**From:** Martyn Chambers [REDACTED]  
**Sent:** 26 October 2020 16:25  
**To:** Fiona Fitzgerald <[Fiona.Fitzgerald@arun.gov.uk](mailto:Fiona.Fitzgerald@arun.gov.uk)>

Cc: Phil Brown [REDACTED] Maria Tomalova <Maria.Tomalova@arun.gov.uk>  
Subject: BE/92/20/DOC - Babsham

I hope you well and don't mind me emailing directly. I have been asked to clarify your queries regarding my report for Basham farm: BE/92/20/DOC. for convenience have copied your concerns below and my response is below:

Figure 1: Site location plan (with sound survey location marked)

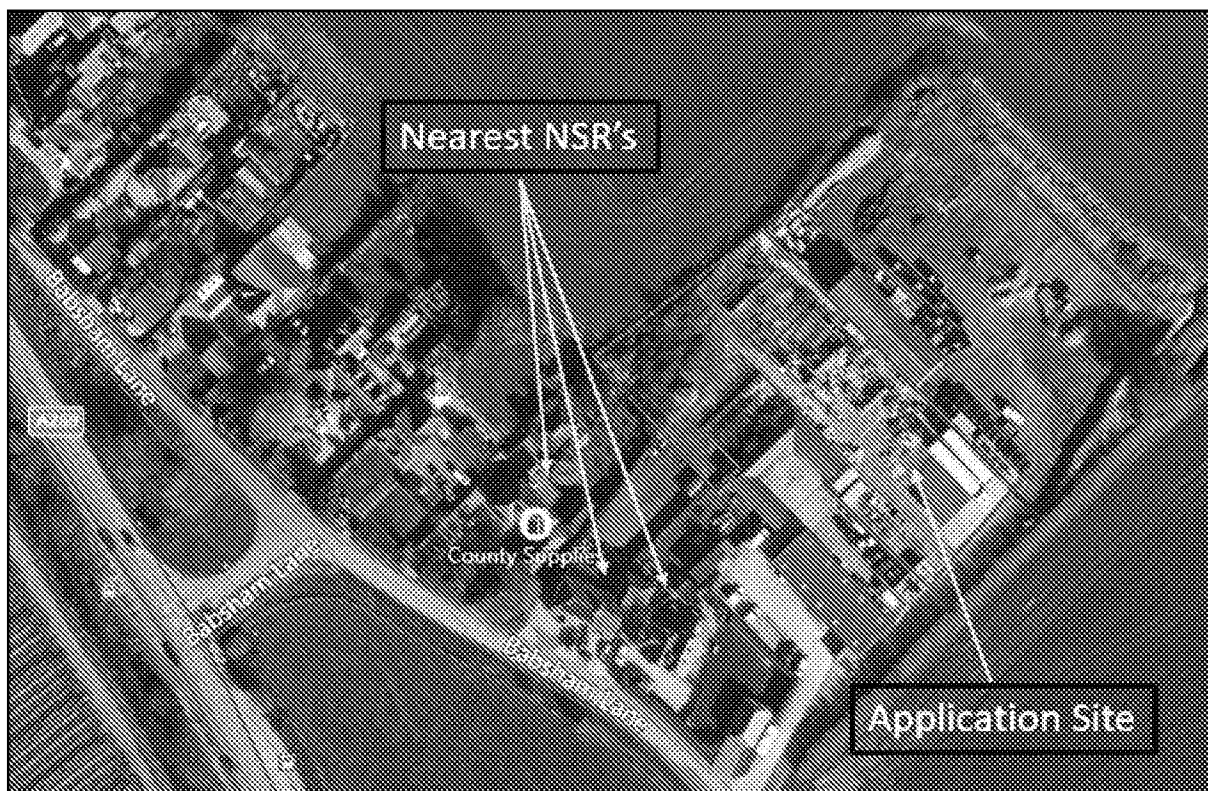
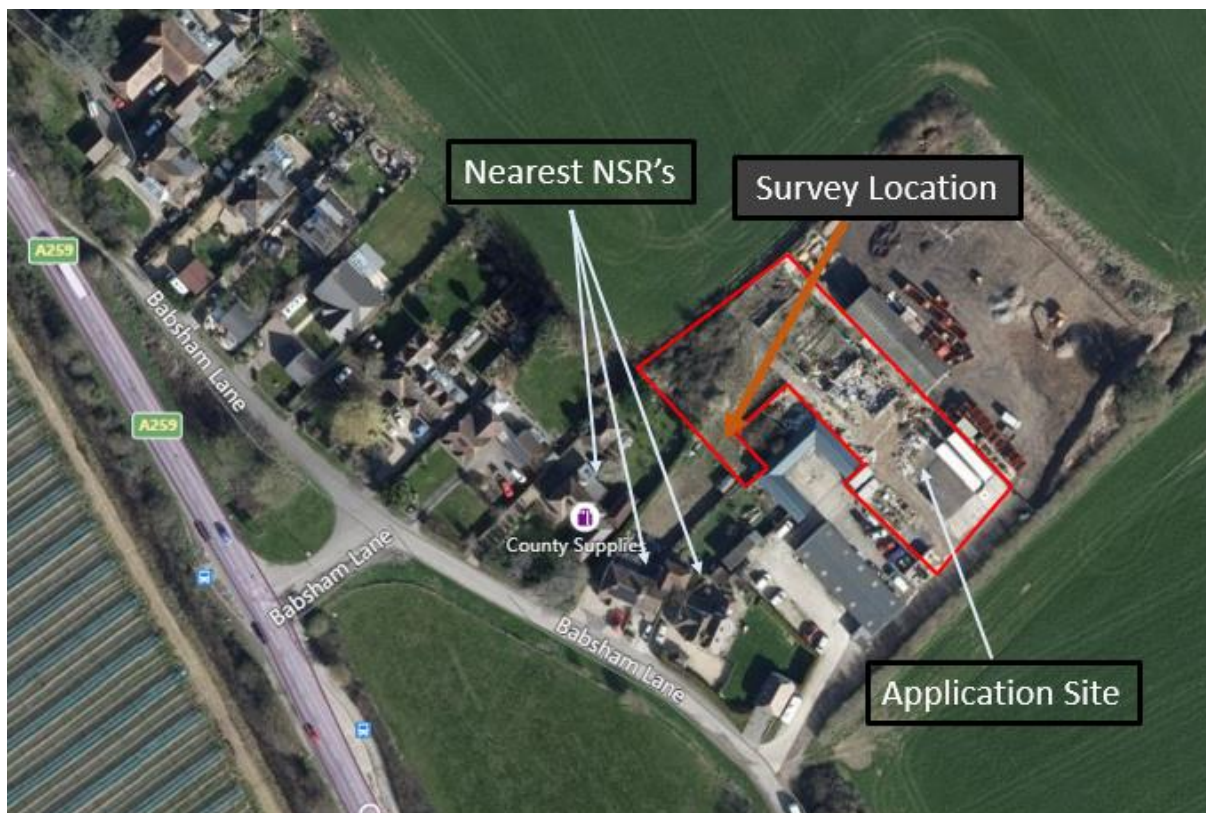
- *Paragraph 3 states that "a sound survey was conducted at the site at a location near to the closest NSR to establish the current background level". Could the applicant please clarify the exact location of the microphone in comparison to the NSR's?*

I have updated figure 1 in the report to show the position of the sound survey compared to the NSR's. A photo of the survey where you can see the NSR's is also shown in figure 3. In terms of measurements, it was at the nearest securable position owned by the client, which was approximately 5m from the boundary of the site. The microphone height was 3m.

Figure 12: Worst-case house noise model

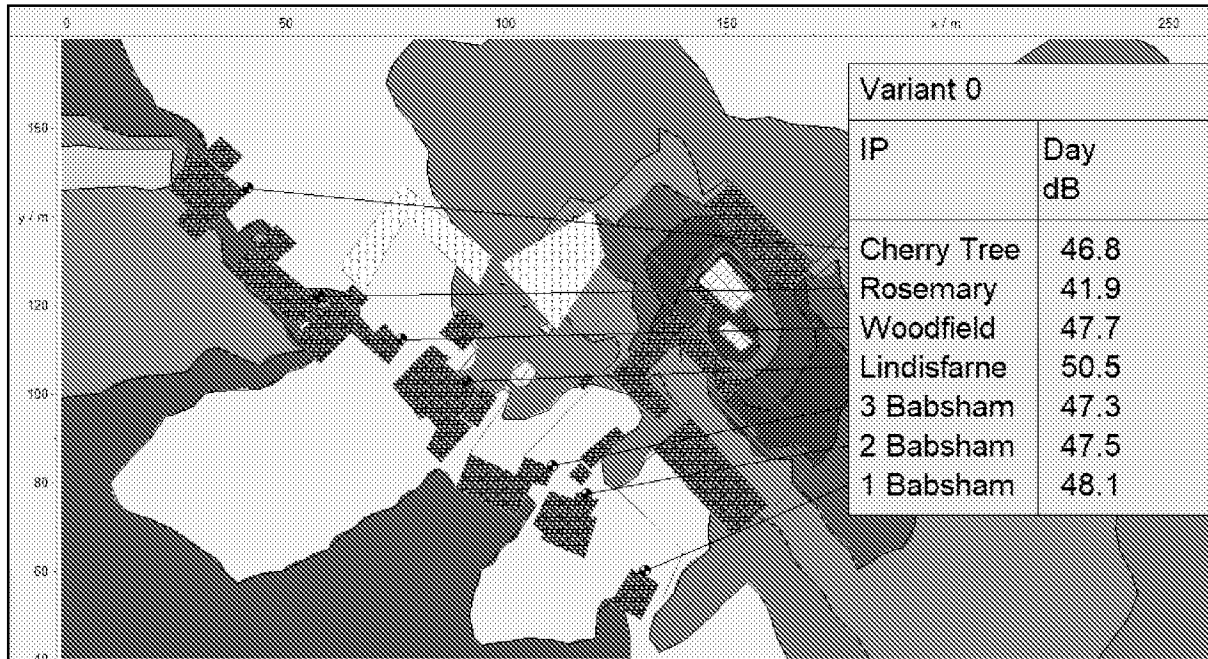
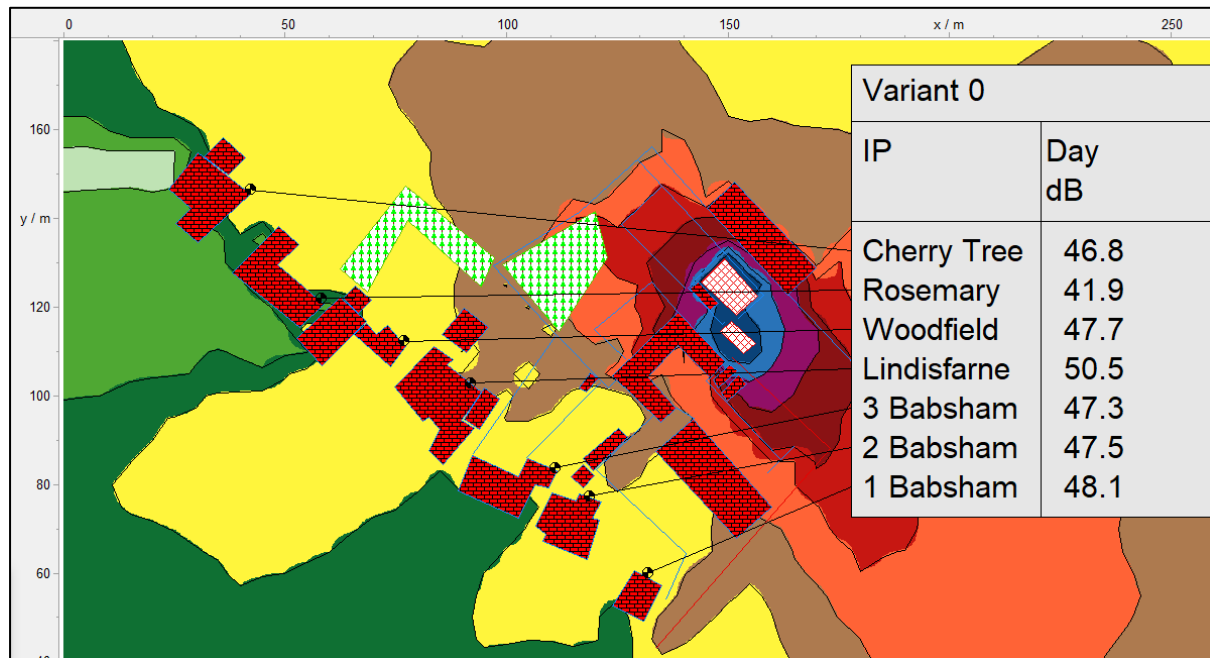
- *Please could Figure 12 be provided in colour?*

Of course, it should have been in colour in the original report so I'm not sure how you got it in black and white, but it is in colour in the report attached and I have included a sperate attachment of just that image.
